From: Maria Tomalova
Sent: 23 February 2022 11:36
To: Planning.Responses
Subject: FW: F/24/21/PL
Attachments: Keith Langmead - ADC - Redstone - South Yard - Ford - CLT - Elevations - 23rd February 2022.pdf

Please replace submitted drawing 002 Rev 01 from 01/12/21 with this in attachment (002 Rev 02).
Elevations & Roof Plan E10326-GA-002 to be deleted.

Please find attached a copy of the correct elevations, with the sky lights removed, for South Yard, Ford, F/24/21/PL.

client			
Keith Langmead			
project			
Proposed Warehouse South Yard Ford			
title			
Existing and Proposed Site Block Plan. Proposed Floor Plan & Elevations.			
date	scale @ A1	drawn	chkd
24.11.21	as shown	gbc	
project no.	drawing no.		rev
2138	002		01

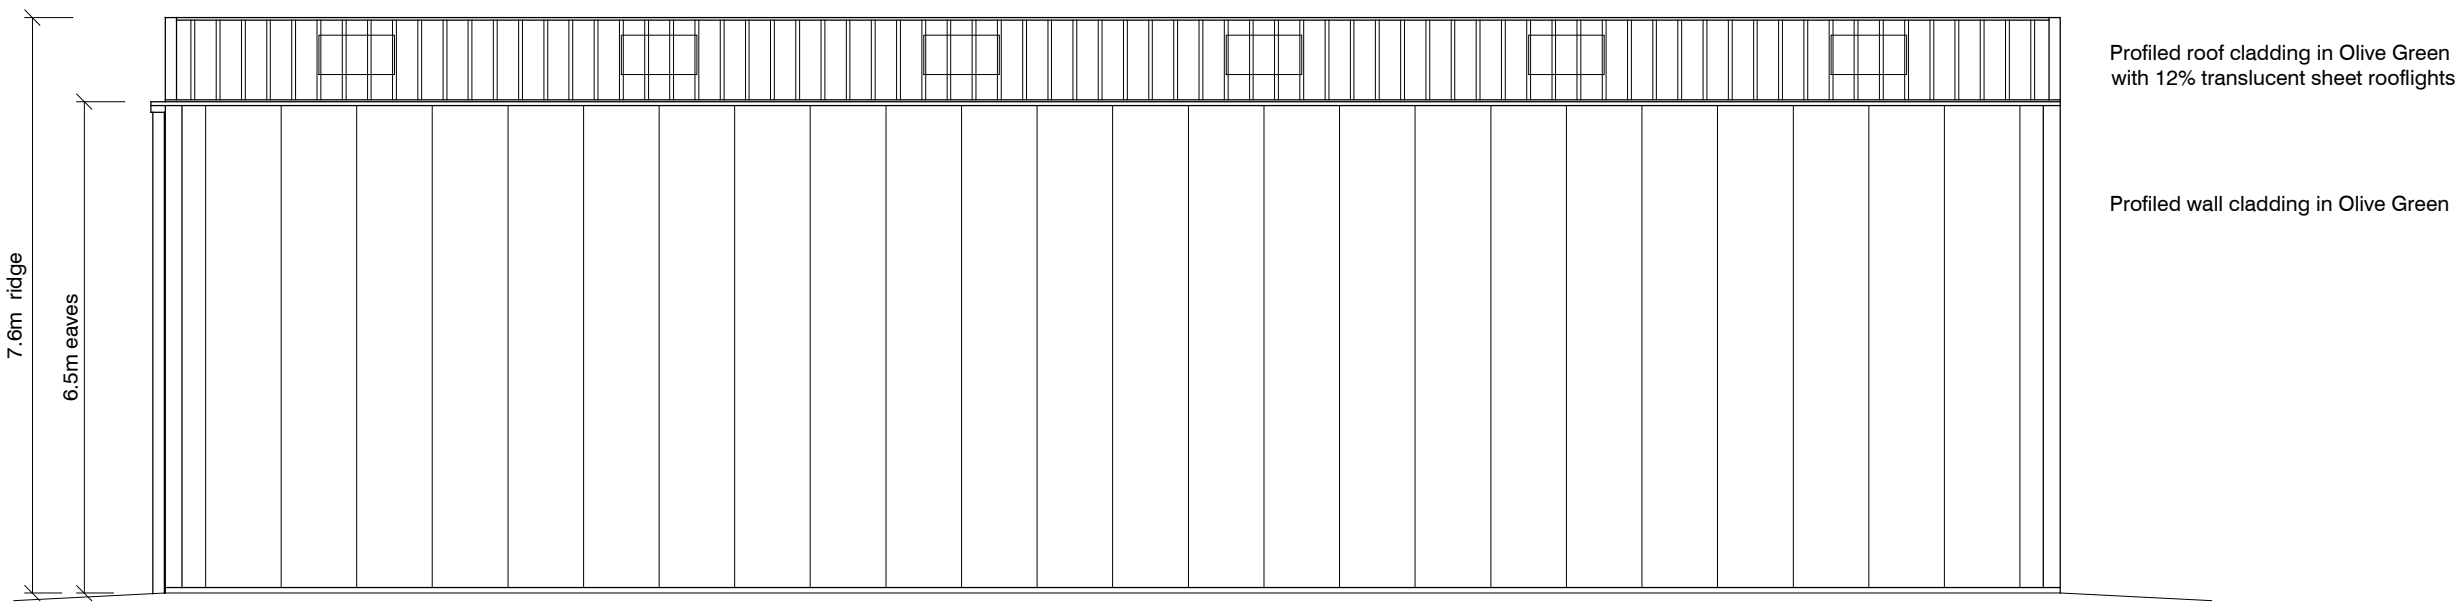
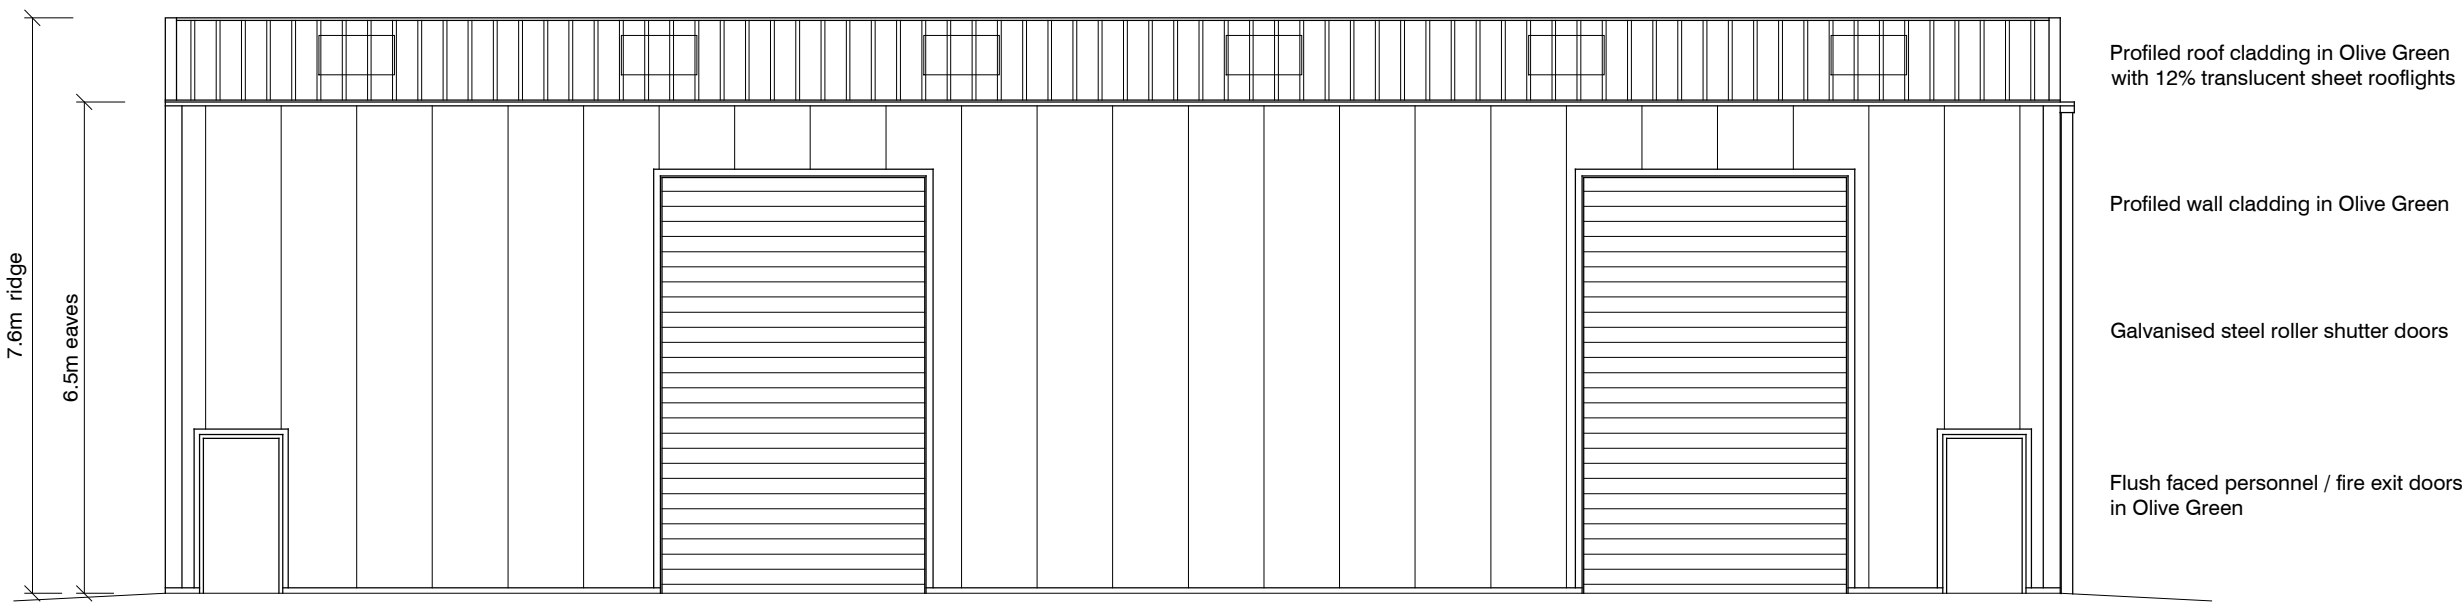
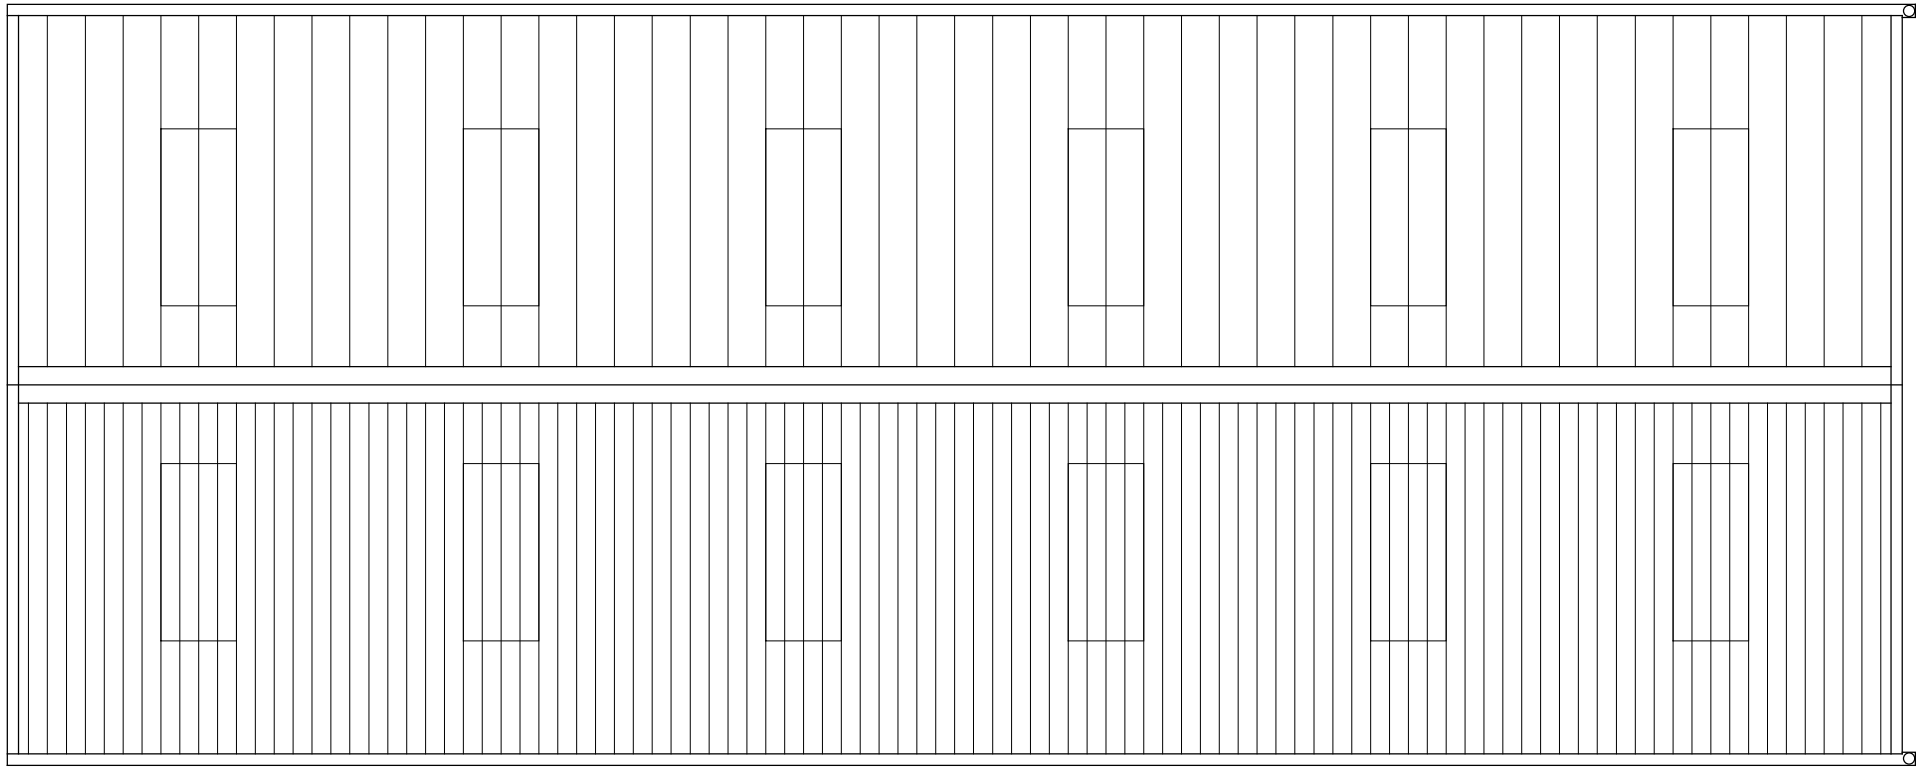
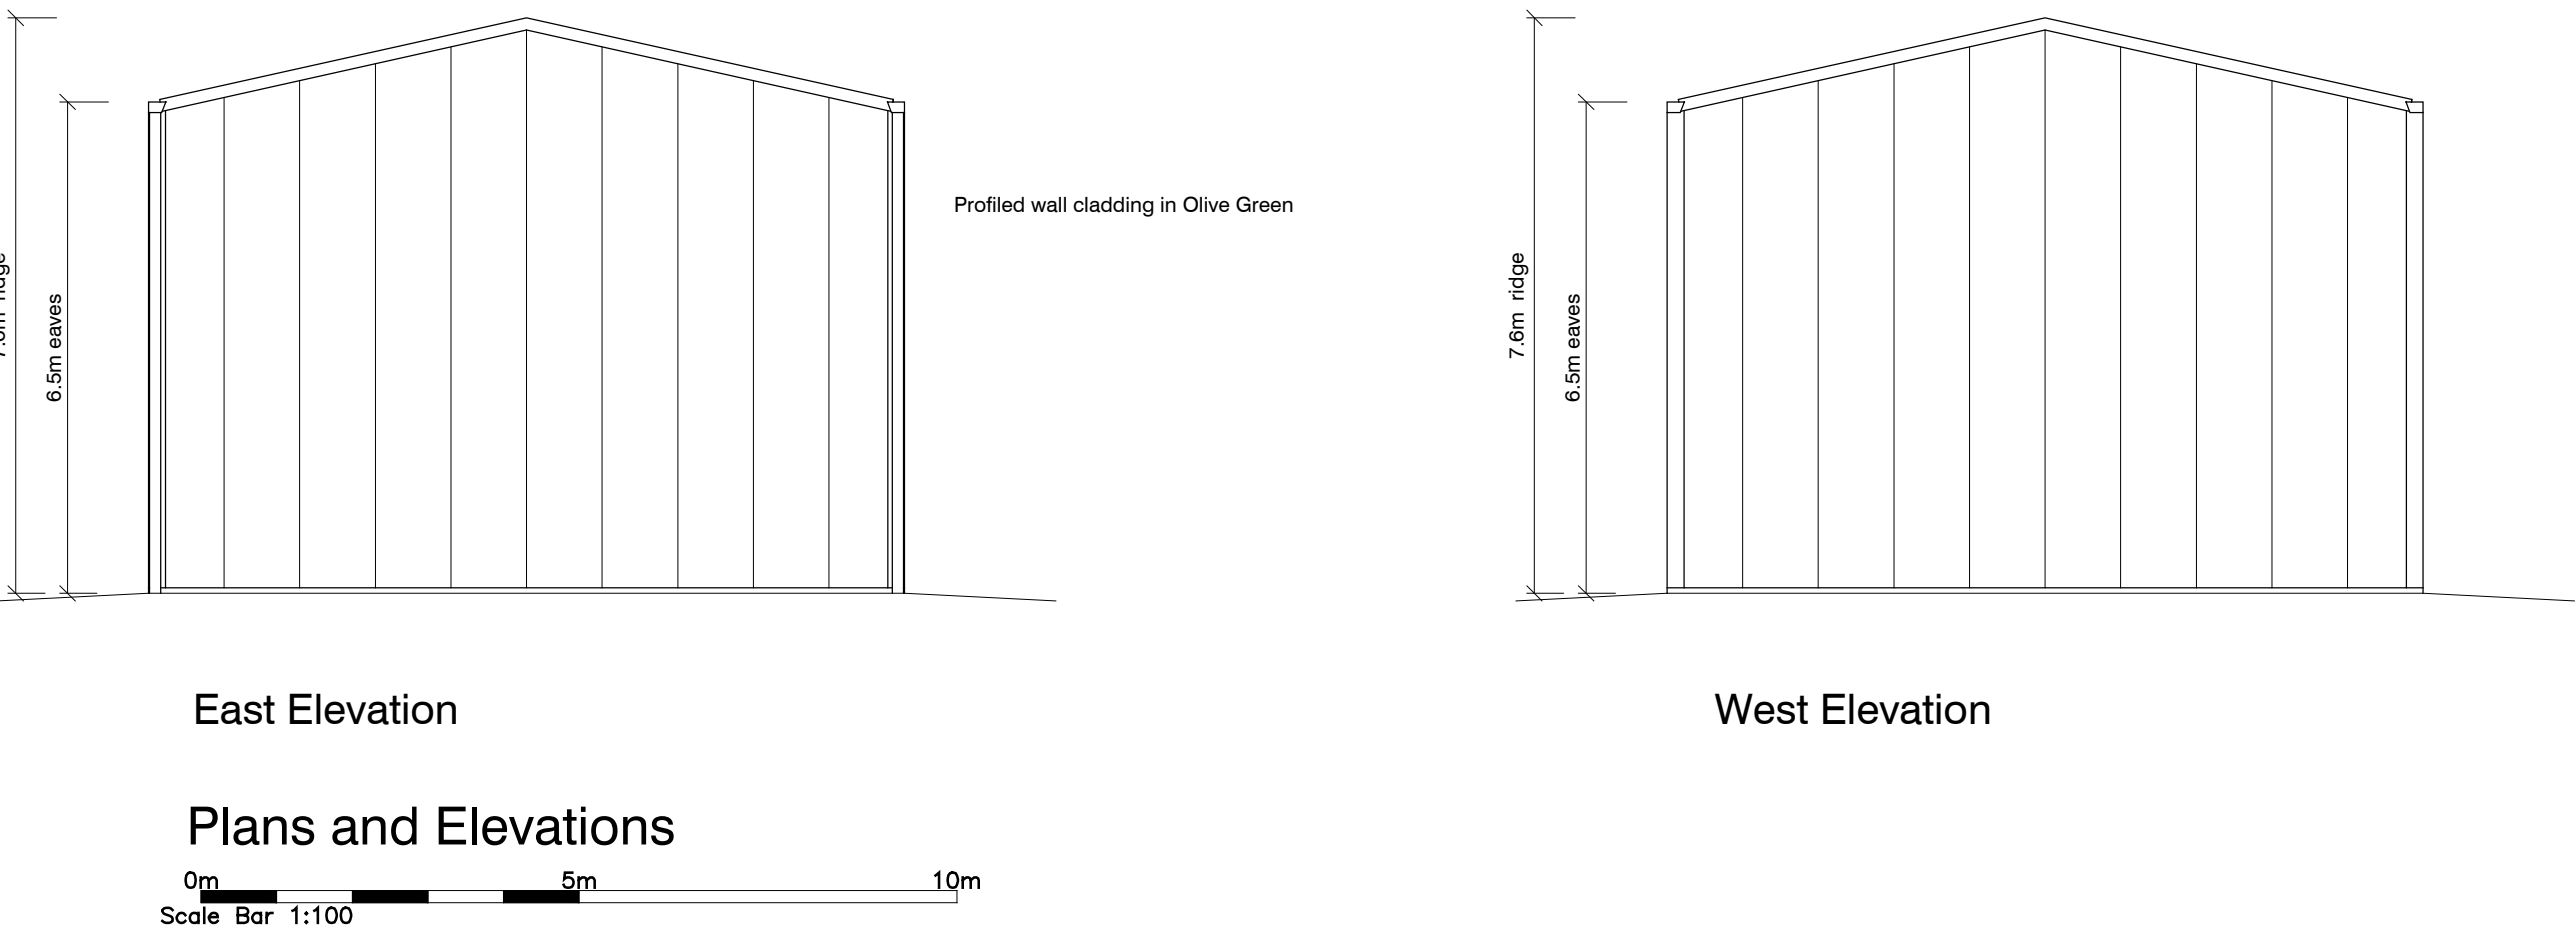
With regards to our recent phone call I am expecting from you the correct drawings; Block Plan matching Elevations & Roof Plan (ideally without a plenty of roof lights) and the confirmation of working hours.
